Your Ref: OWPC21836
Our Ref: EP/16/19/HH 07-02-2019
Please ask for:
Zac Denton

Single storey rear extension with an addition of a second floor including a rear dormer and gable end window

2 Hillview Crescent East Preston

DRAWING TITLE
Proposed Elevations

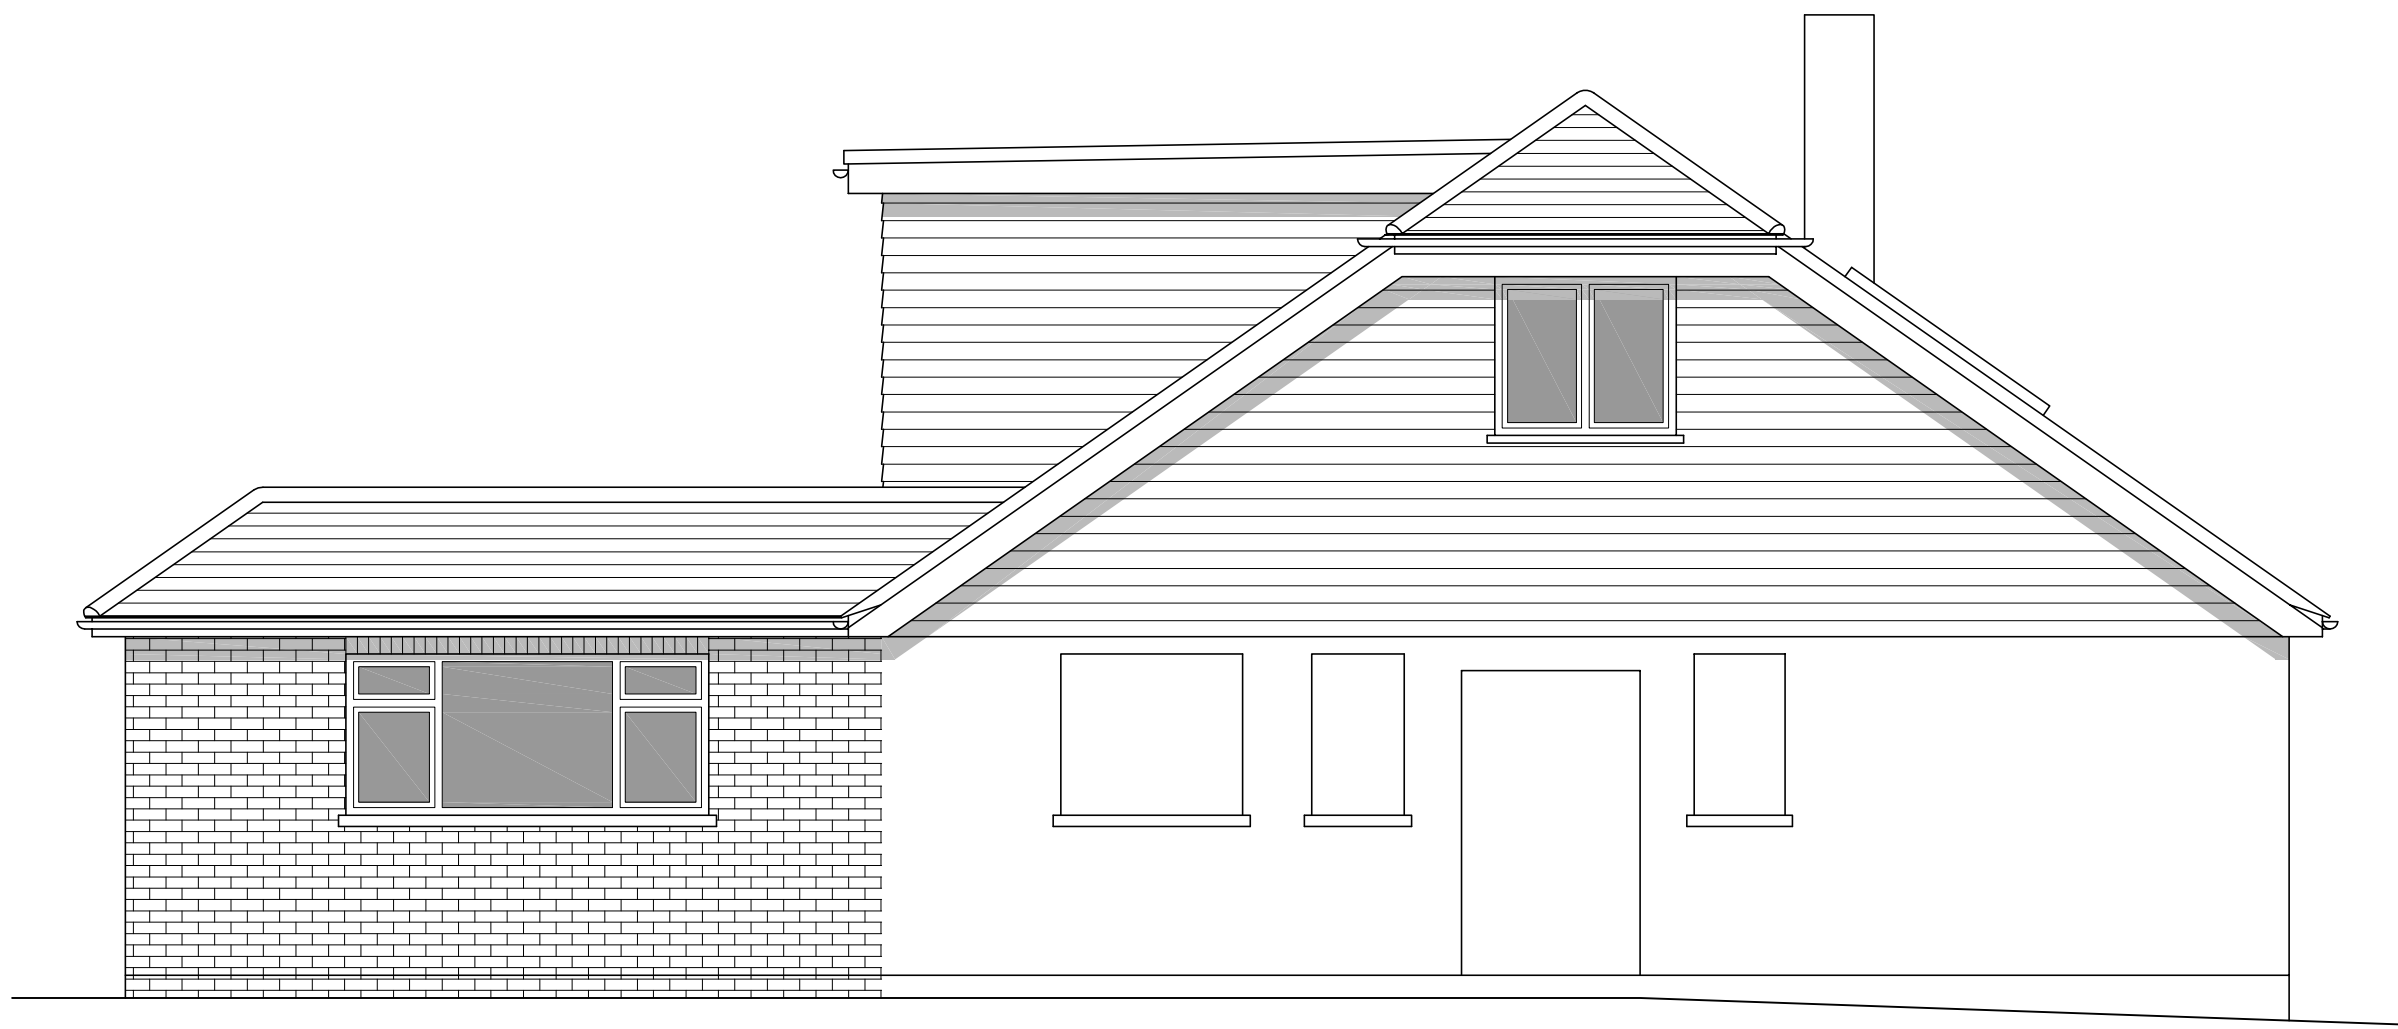
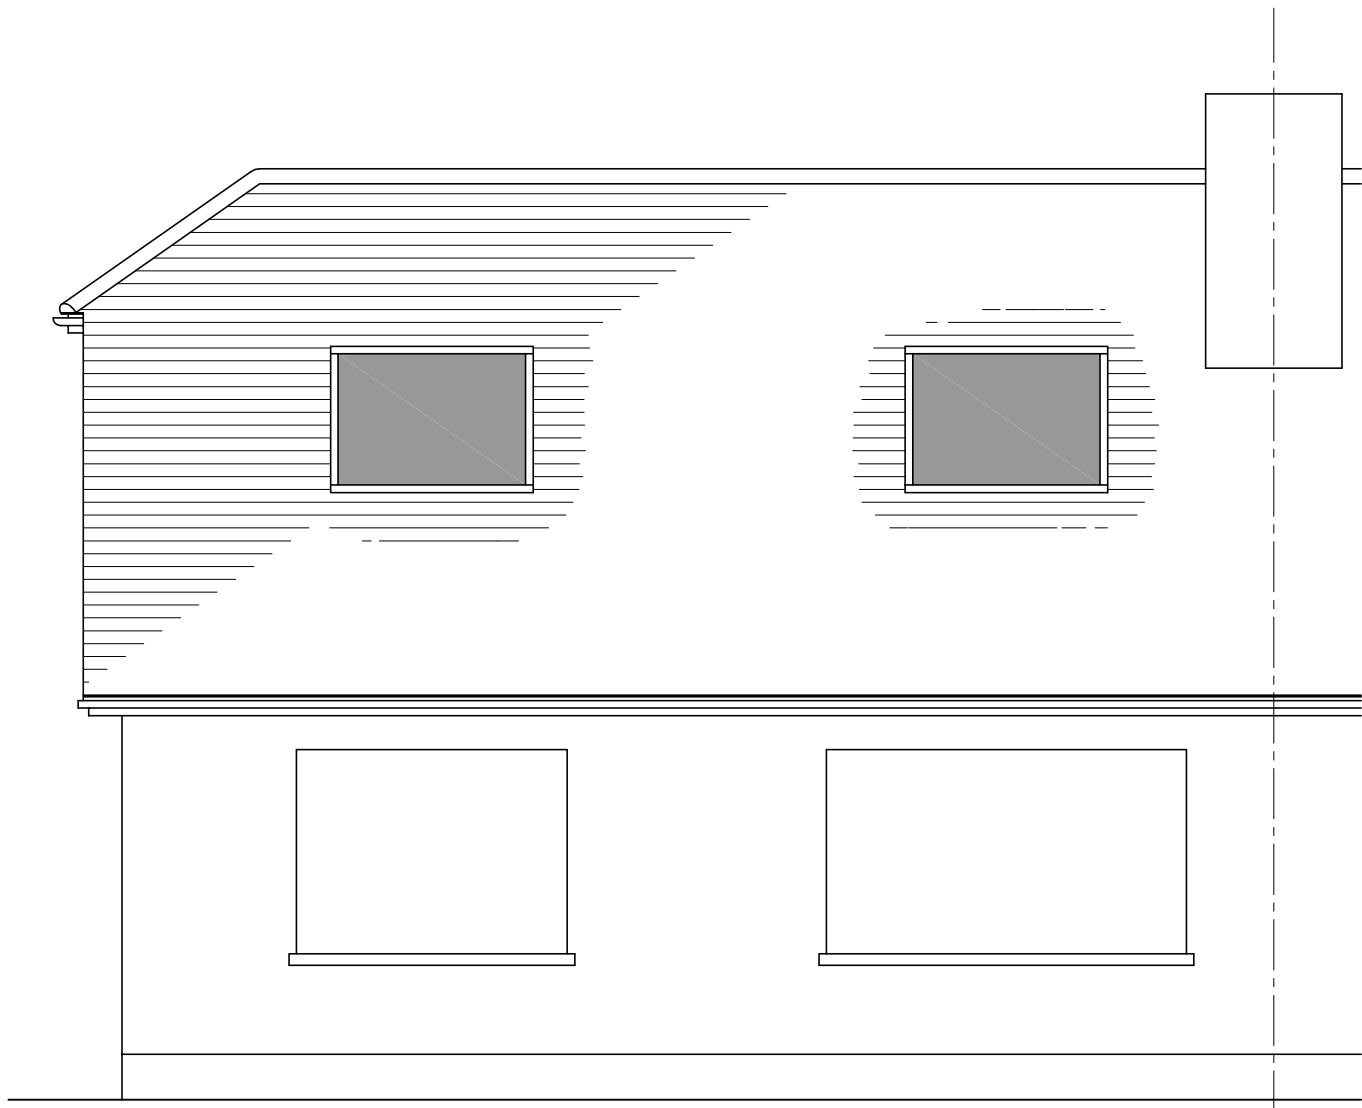
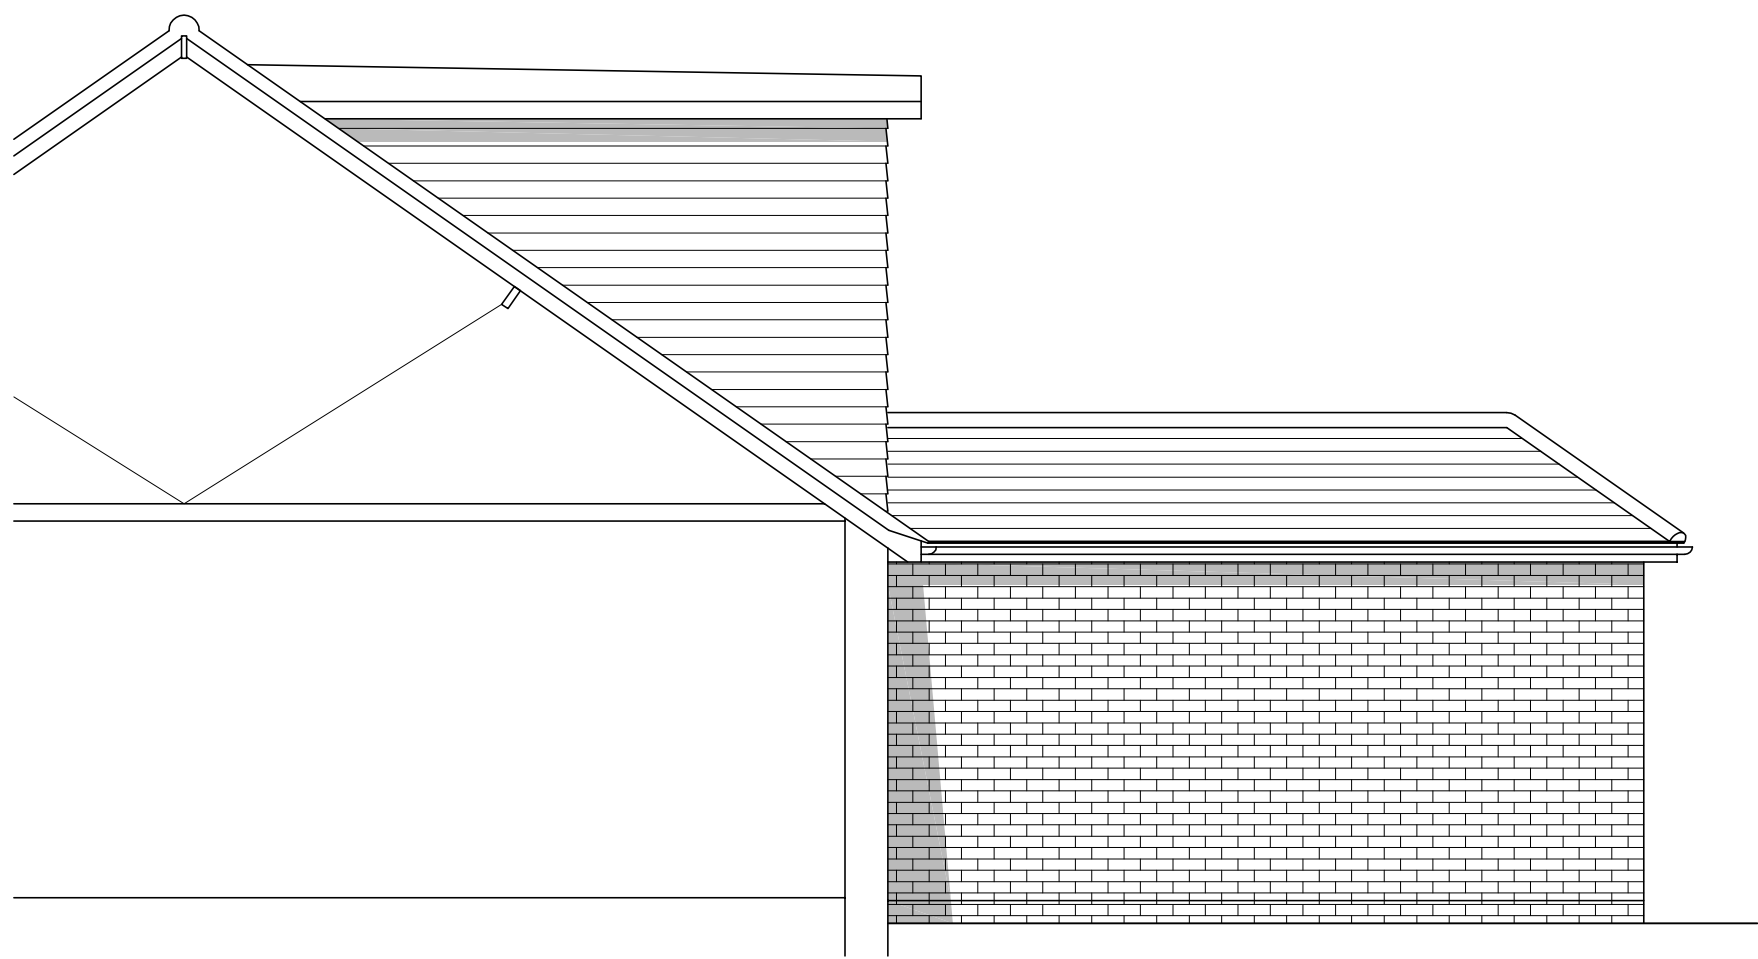
Having looked at the plans, I'm extremely concerned of the effect that the size and prominence the dormer is going to have on our and neighbouring properties. We are going to be directly overlooked, with the windows looking straight into our garden and conservatory as they back directly on to the back of our property. Obviously this is going to take away our enjoyment of both of them and is totally unacceptable, through no fault of our own. As the Parish Council have stated the street scene will be detrimentally affected from all angles and especially ours, having to look at a huge box stuck on the back of the bungalow that will visible from every where in our property. This will not be in keeping with the rest of Orchard Road.
